WEST SUSSEX COUNTY COUNCIL CONSULTATION

TO:	Arun District Council FAO: Maria Tomalova
FROM:	WSCC - Highways Authority
DATE:	6 May 2020
LOCATION:	Hales Barn Farm, Arundel Road, Aldingbourne, BN18 0JX
SUBJECT:	AL/31/20/PD Notification for Prior Approval under Part 3, Class PA for change of use building (Class B1(c)) to 1 No dwelling (Class C3).
DATE OF SITE VISIT:	N/A
RECOMMENDATION:	Advice
S106 CONTRIBUTION TOTAL:	N/A

Drawing 3 - Proposed Site Plan

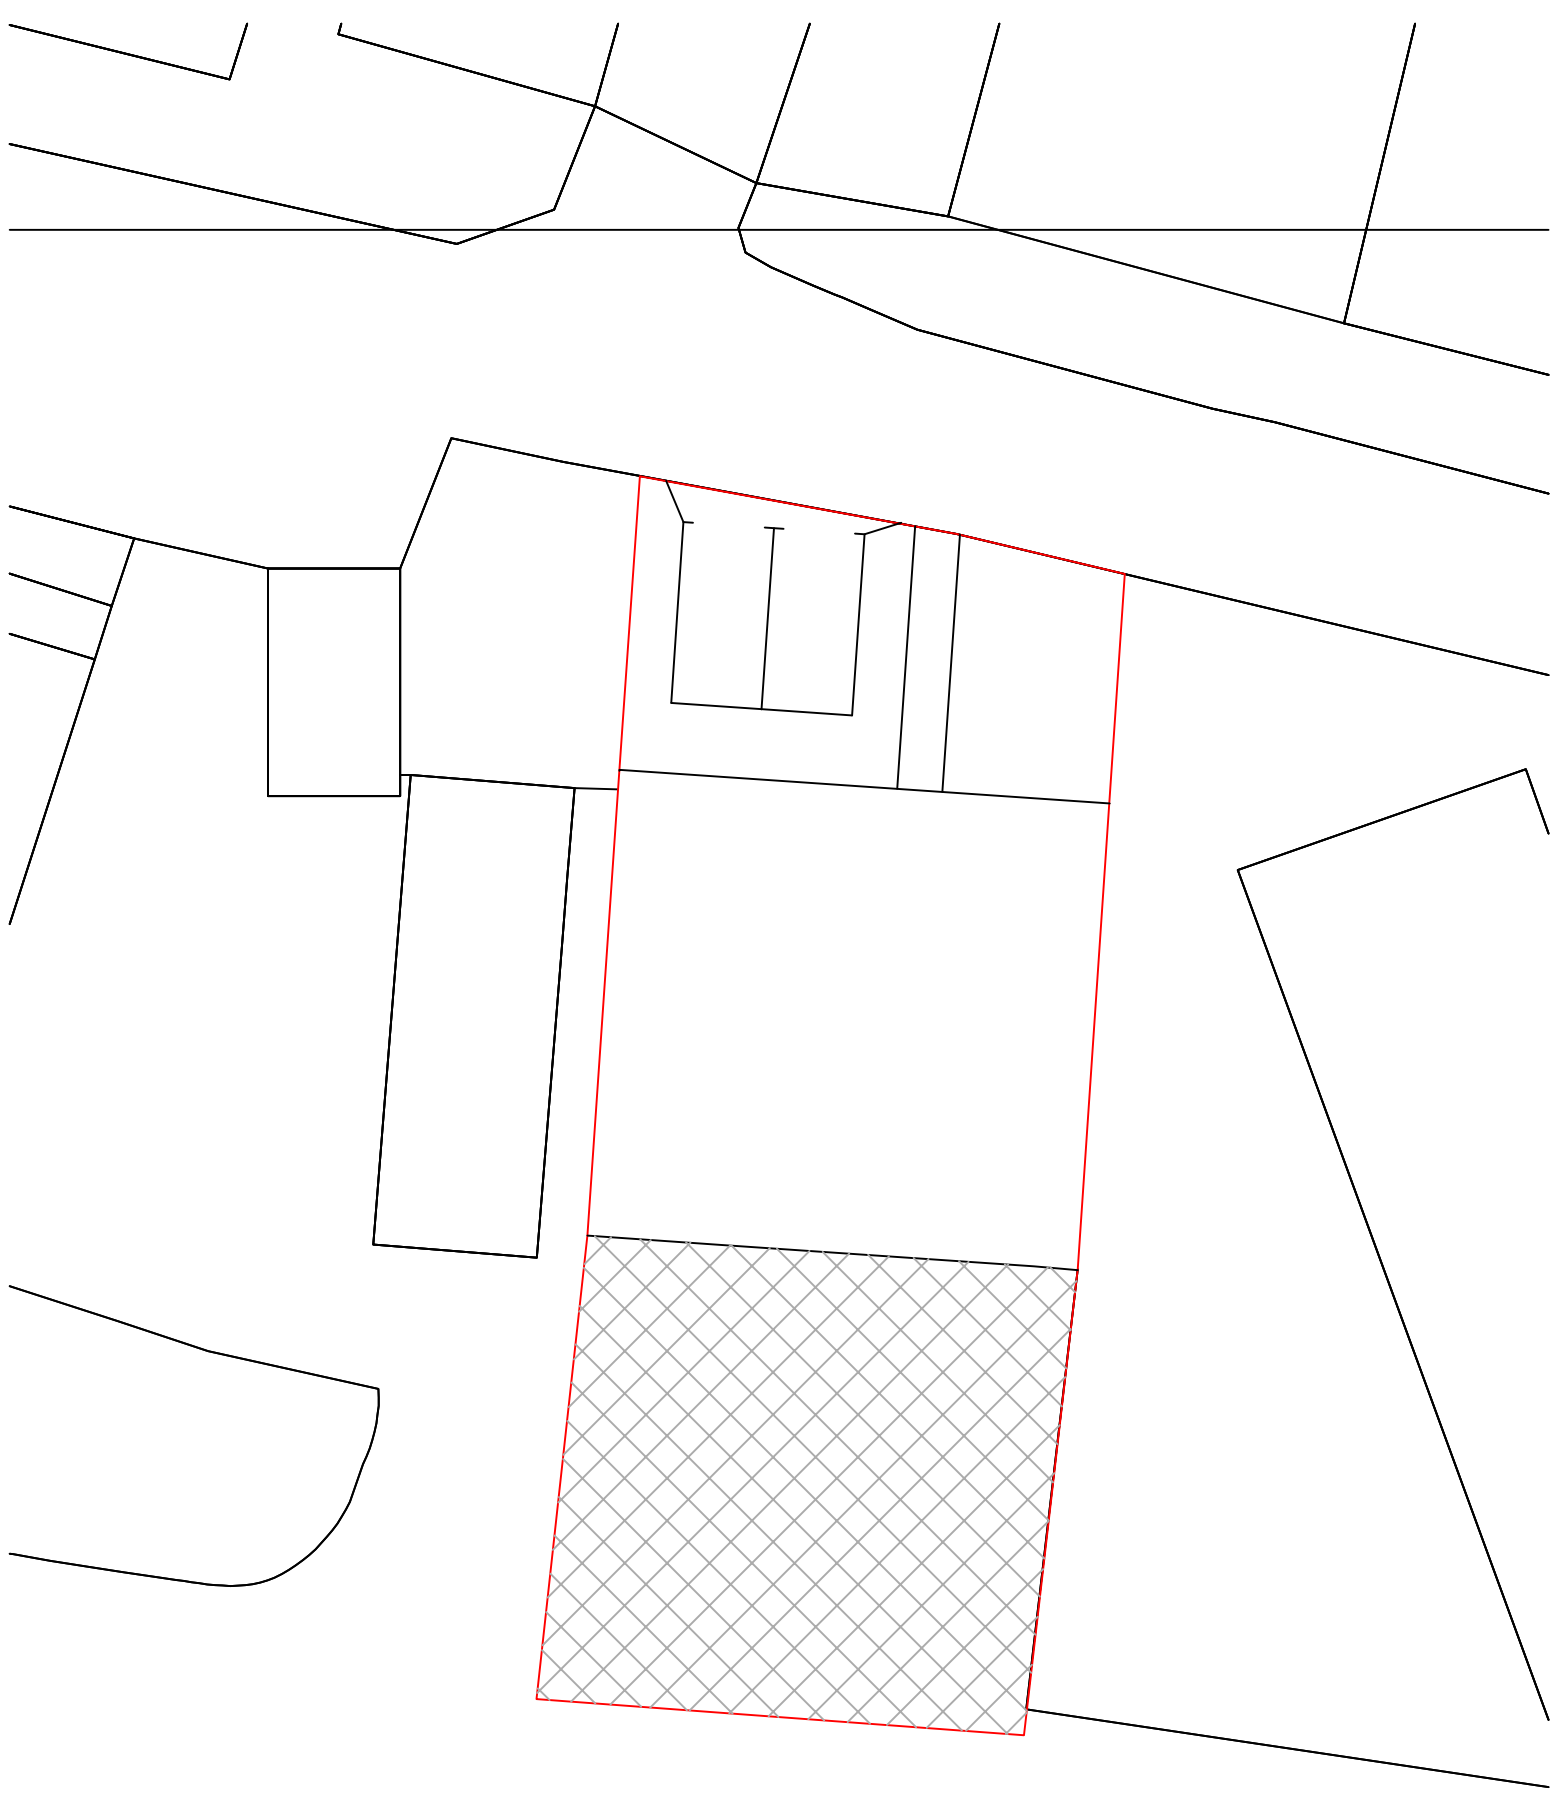
The proposed parking provision of two parking spaces is anticipated to be sufficient for a dwelling of this size and location. In addition, the LHA appreciate the sustainable location of the site, situated within close proximity to local shops, bus services and a train station, and consider that there are viable options for sustainable modes of transport to reduce the reliance upon the private car. Furthermore, the LHA anticipate that the level of traffic generated by this proposal would not result in an increase over the potential traffic generated through the office use.

If the Local Planning Authority is minded to approve the application, they may wish to condition cycle parking.
